**Consultation Response from KC,
Lead Local Flood Authority**

2025/91905 Land at, Woodhead Road, Honley, Holmfirth, HD9 6PU

Erection of temporary veterinary surgery and associated works

Date Responded: 22nd August 2025

TITLE EXISTING DRAWING
SITE PLAN
TEMPORARY SURGERY BUILDING
SCALE 1:200 @ A1

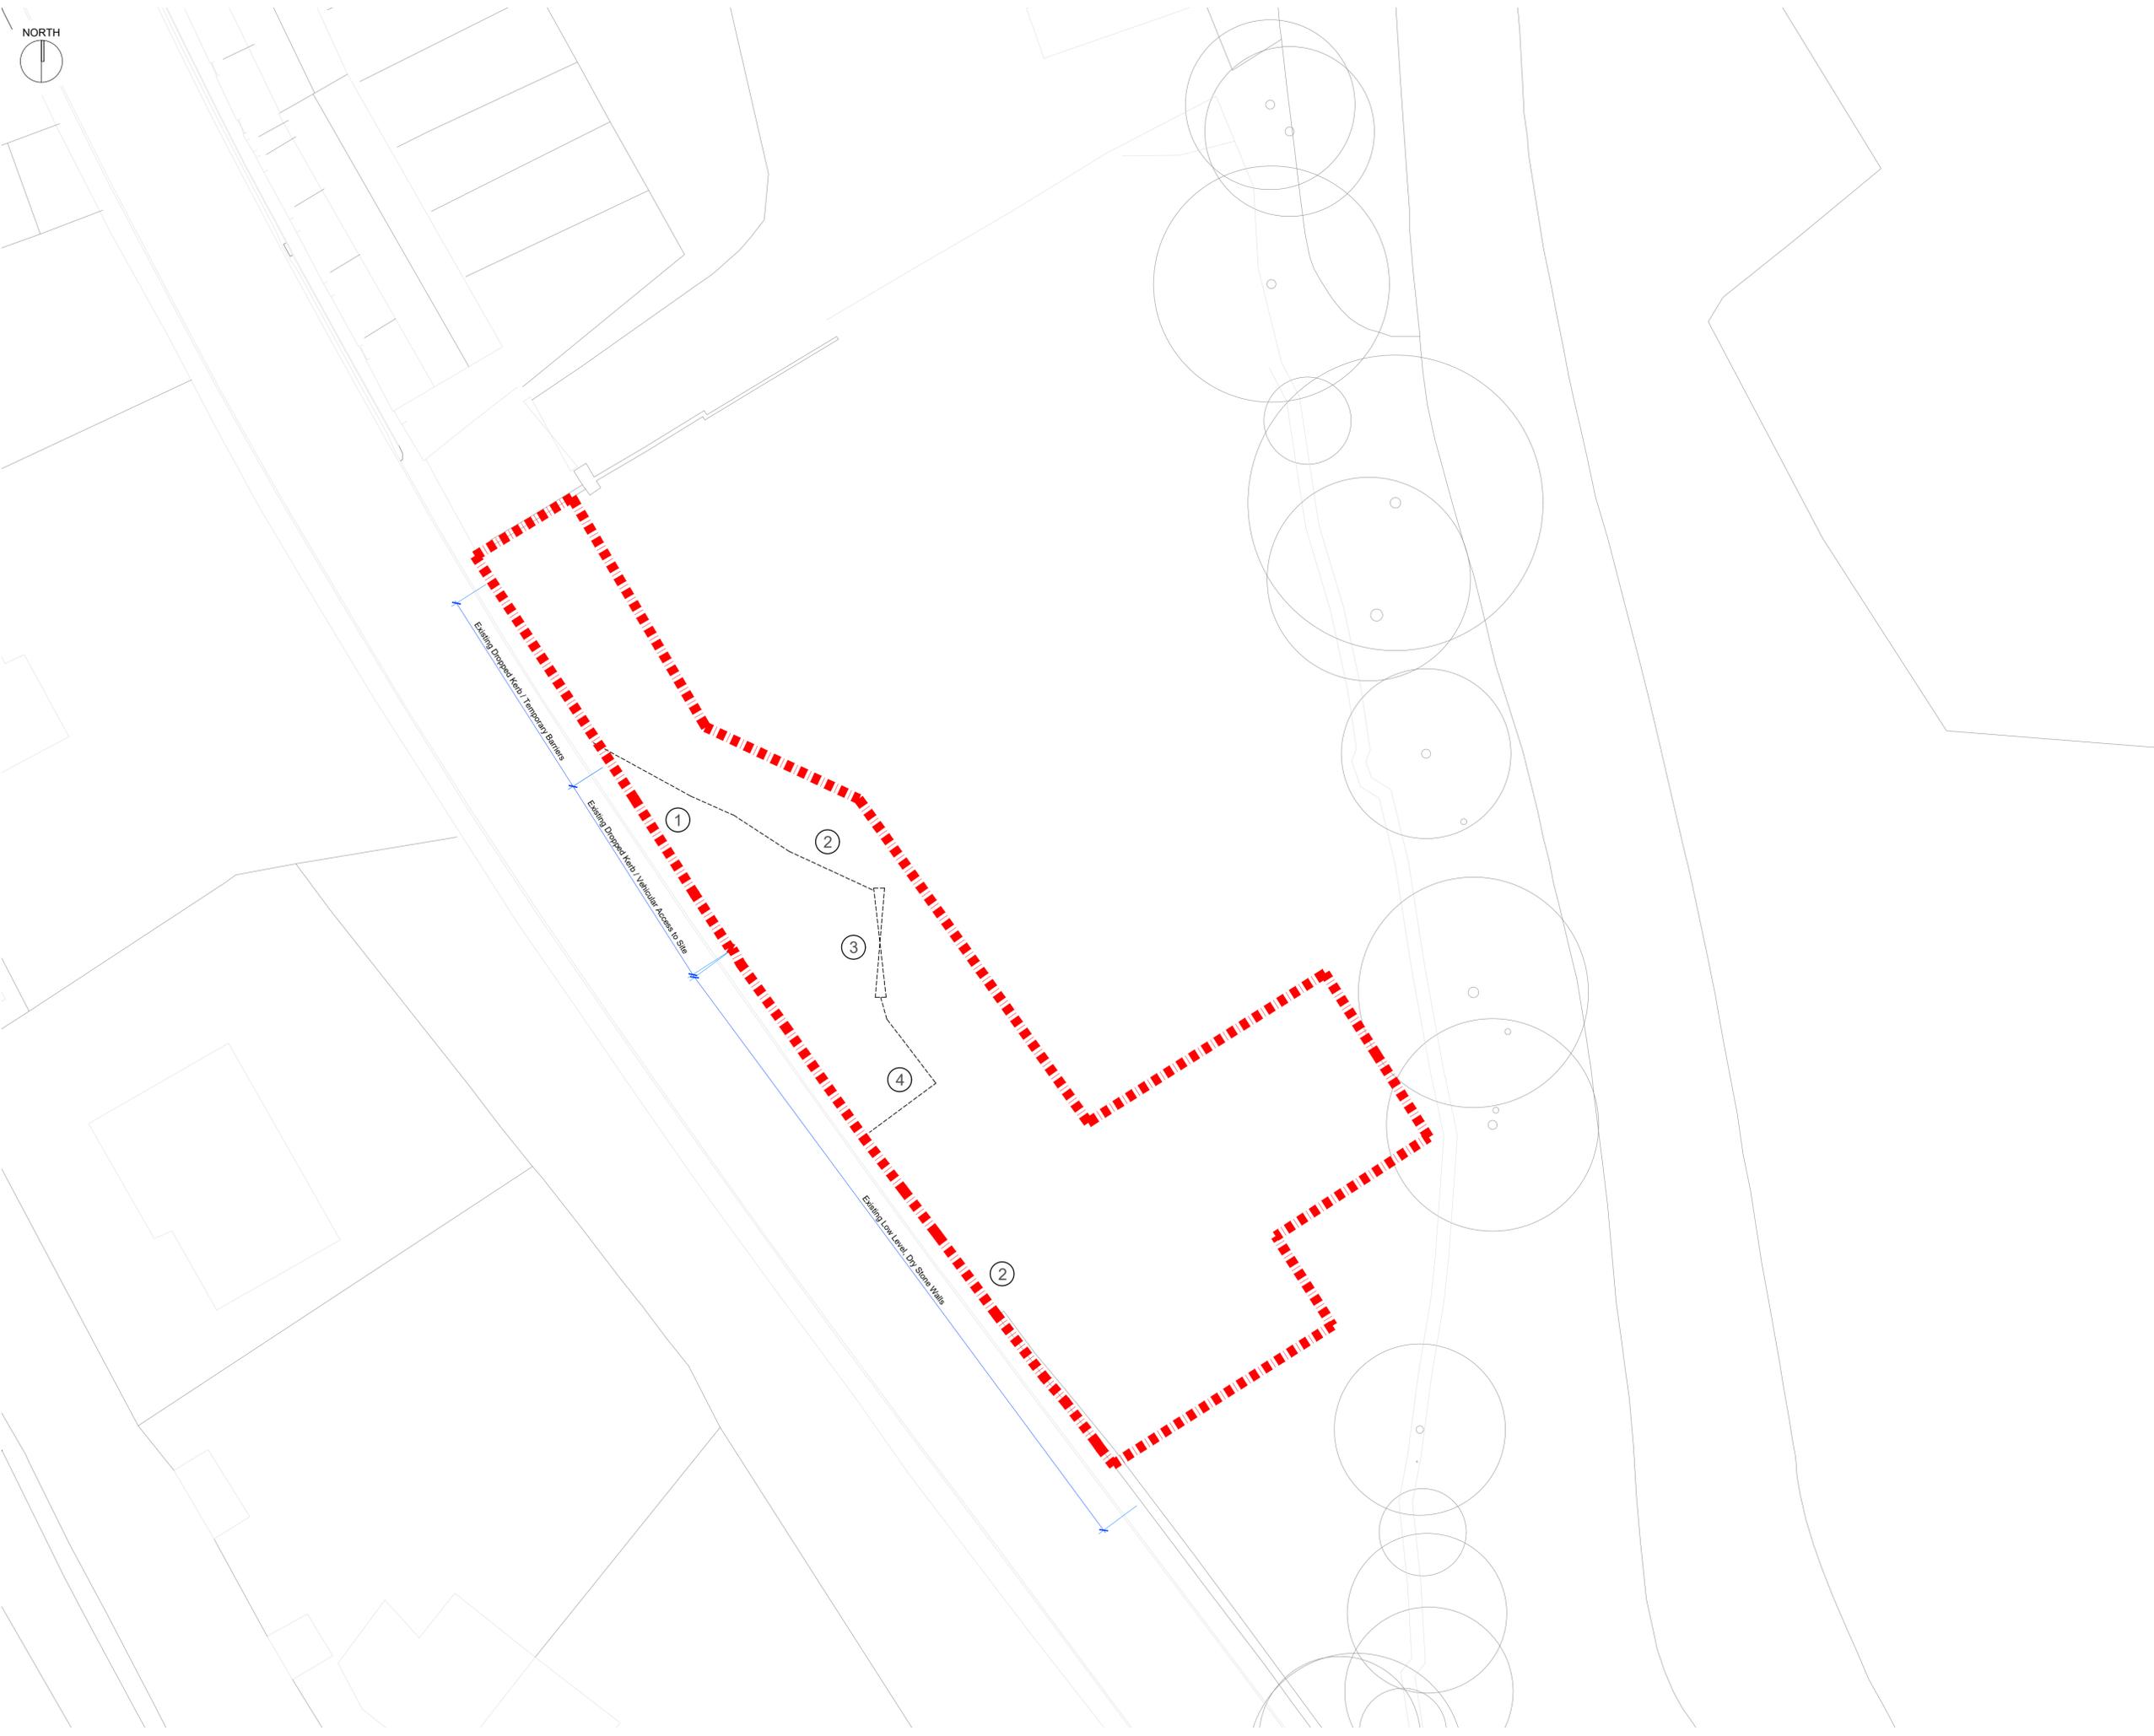
The applicant has elected to show a connection to public combined sewers and cited constraints at the eastern border of the site, stating that these are protected roots areas. The Planning Officer needs to speak to Woodland Management on this matter. A 6-metre easement would be required to create an outfall from site to the river which is expected.

Should the planning officer concur that a connection to watercourse cannot concur in the line with the hierarchy of preferable surface water discharge location, then it needs to make sure that any future development can be covered by gravity. Therefore, can it drainage from the lowest part of the site adequately drain to the oversized storage pit shown on submitted drawings
